Subject: Response to National Grid DEADLINE 15

Q5.9.5.2 The Applicant; National Grid Finishes for National Grid substation extension a) Further to requests and comments at OFH3, can the electrical equipment required for the National Grid substation extension be coated or manufactured with a matt finish? b) If so, the Applicant is requested to include relevant wording to secure this either in the DAS or in the OLEMS. National Grid understands that the “electrical equipment” referred to specifically relate to busbars. Typically any electrical equipment installed at National Grid substations is either painted by the equipment manufacturer or left bare. In the case of the busbars National Grid do not paint or coat them as it will negatively affect the thermal carrying capability of the assets. Overtime the busbars will dull as they oxidise. If the Examining Authority is referring to any other electrical equipment National Grid requests that they are informed about such equipment and consulted on any painting or finish.

Title:	Scenario 1 Viewpoint 4: A47 Necton Substation
--------	---

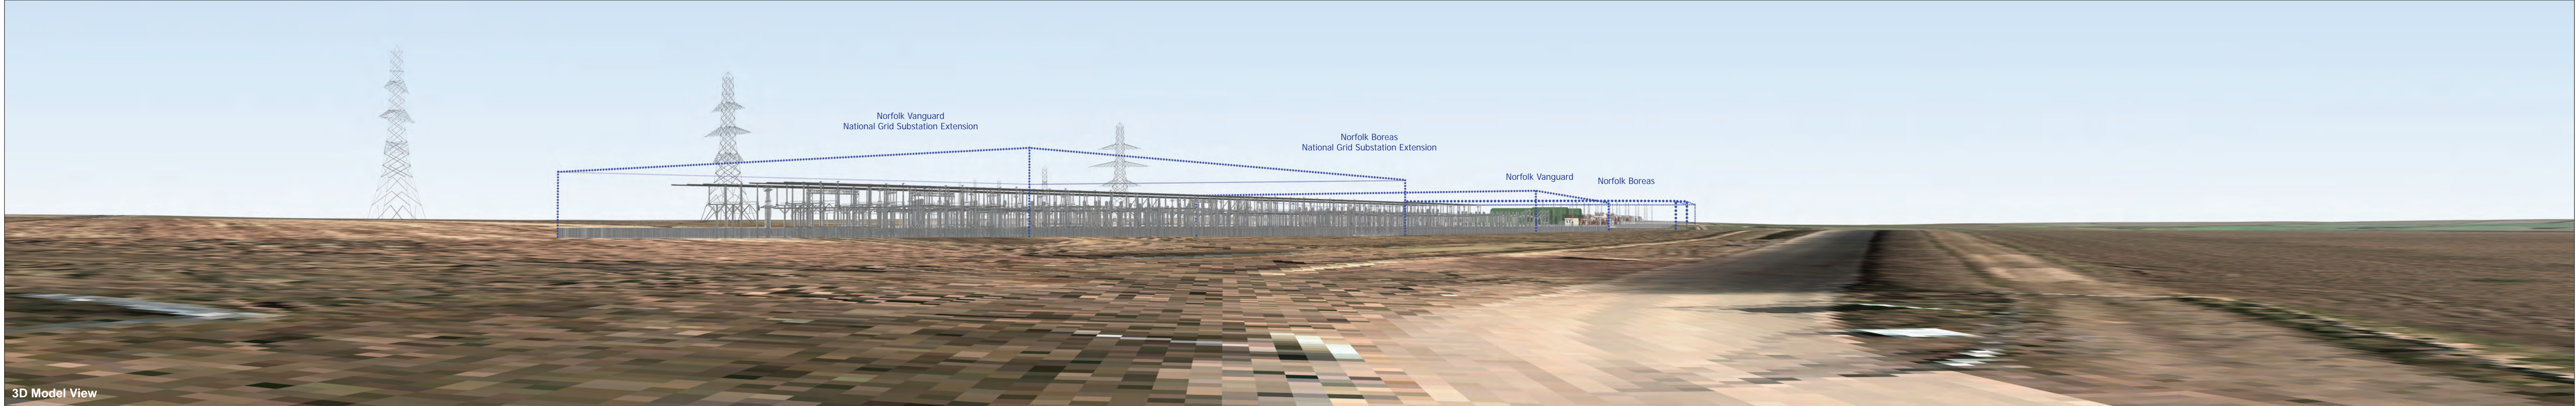
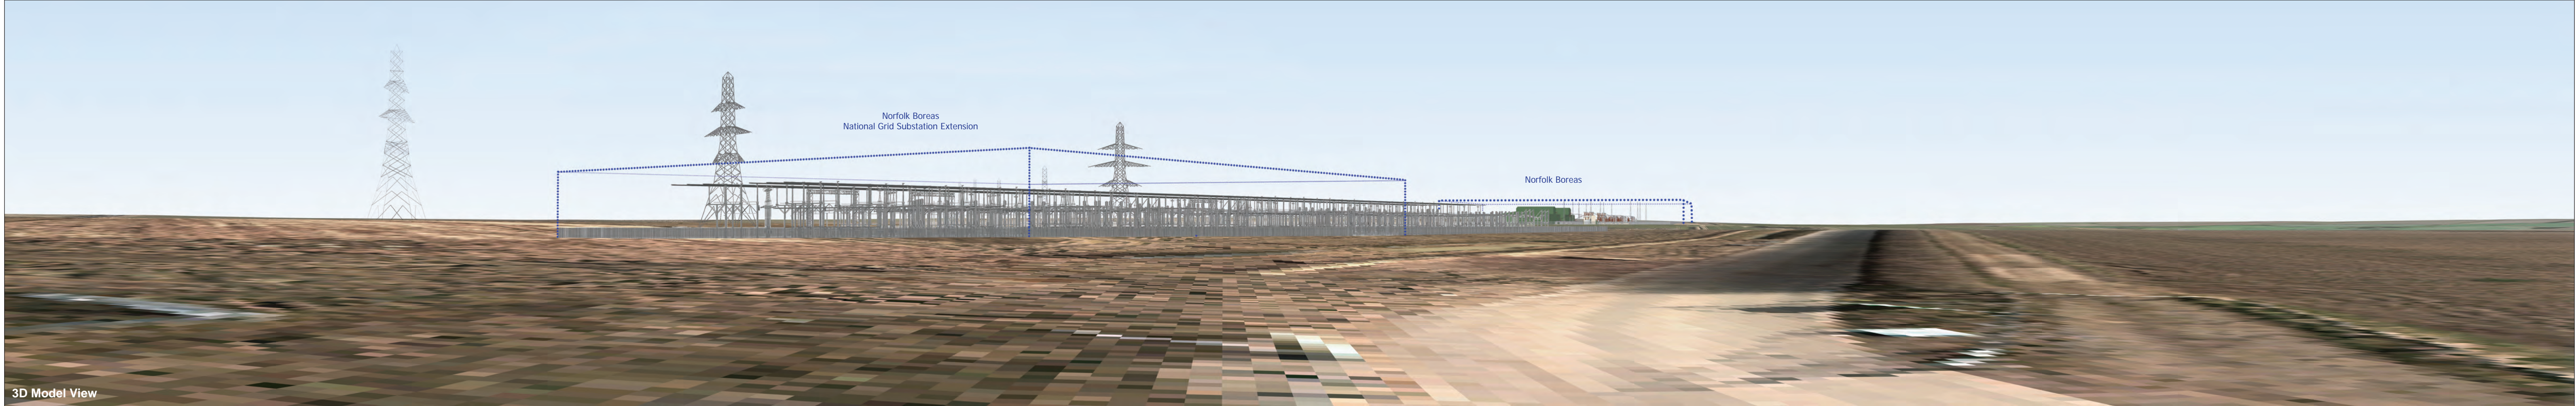
1. If the manufacturer sometimes paints the busbars, why would they not do so in this project?
2. We question the ambiguous use of the words 'over time'. The Dudgeon Substation was started in 2014 - so 6 years ago. There has been no sign of the busbars dulling? How long is 'over time'?
